LORETO KIRRIBILLI LIMITED
85 Carabella Street, Kirribilli
New South Wales 2061
12/08/2019

Modification 1 Loreto Kirribilli - Section 4.55(1A) Modification (SSD-7919-Mod-1)
Request for Additional Information

project code	sheet no.	revision
LKIC	DA-3003	02

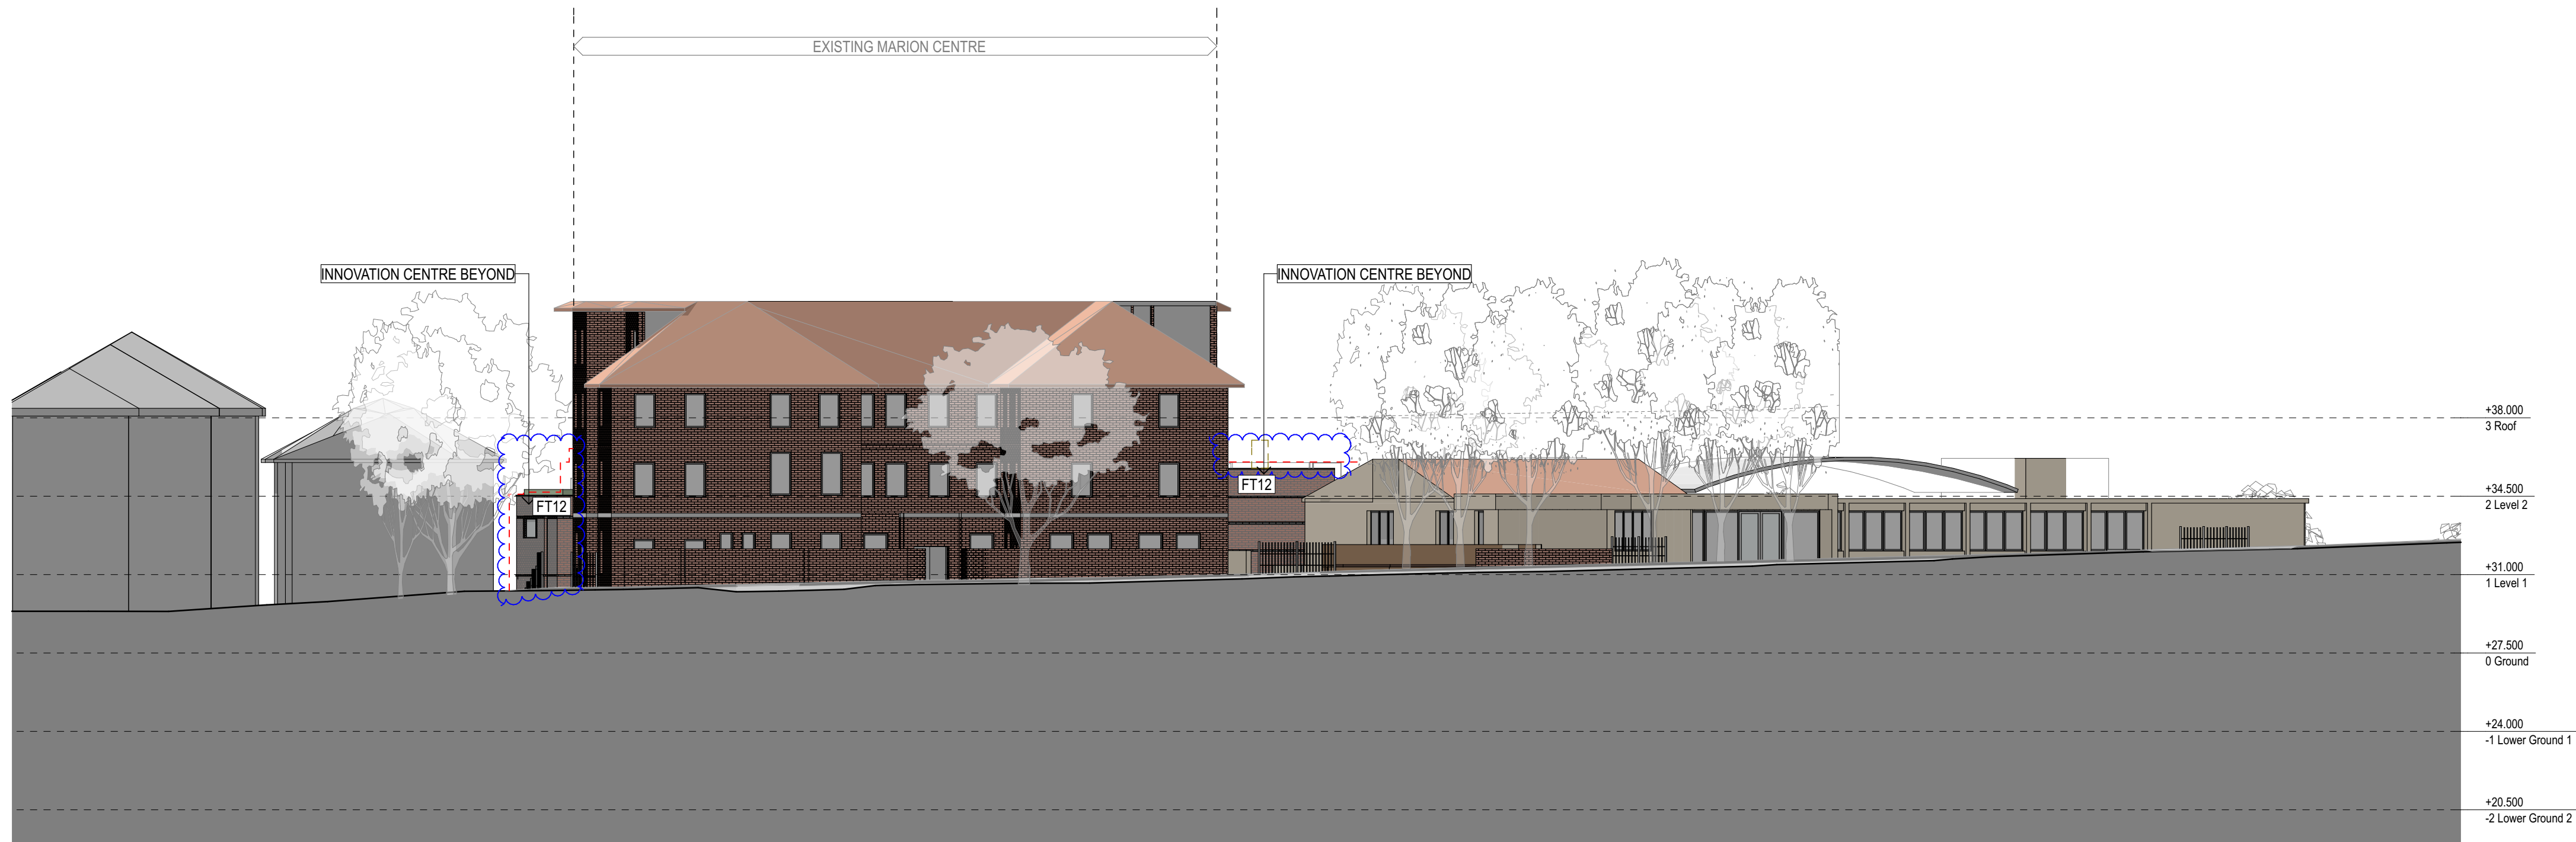
These elements / features are not reflected on the Western elevation (drawing no. DA-3303 Rev 1). Please clarify what these features are (including any retaining walls in the excavated area and amend the elevation to include the additional elements including the windows, if any.

2. An emergency walkway is proposed along the western elevation of the gymnasium, which would extend to the landscaped deck at the Elamang Avenue frontage. Please confirm whether a balustrade is proposed along the western edge of this walkway. Currently, the plans do not indicate a balustrade, however it is shown on the western elevation (DA-3303 Rev 03).

Drawing Number 006
Issue F
Date 10.09.2019

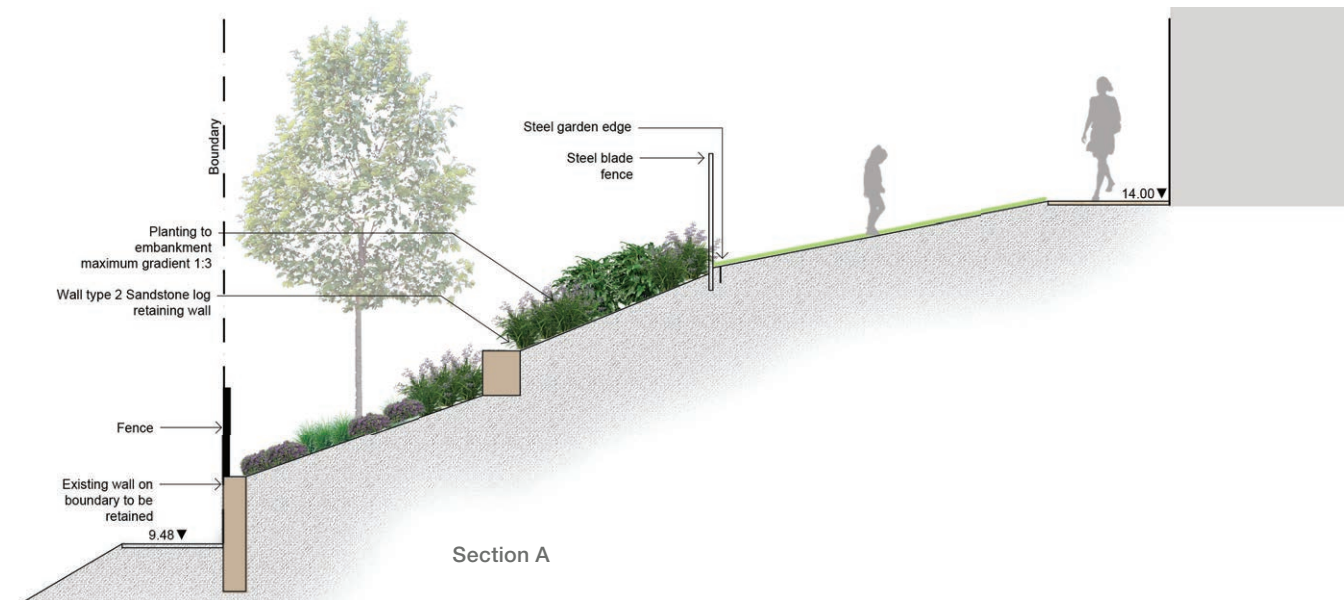
3. As previously requested by the Department, the landscape plans are required to include all Relative Levels (RLs). The Department notes that the landscape plans for Stage 1 generally include levels except the western section (adjoining the gymnasium) where an embankment is proposed. Please provide the RLs to confirm the top and bottom of the landscaped embankment between the walkway and the site boundary. In the case where an embankment is not proposed at this location, please confirm whether the walkway is proposed to be supported on columns (currently not shown on plan or elevation).
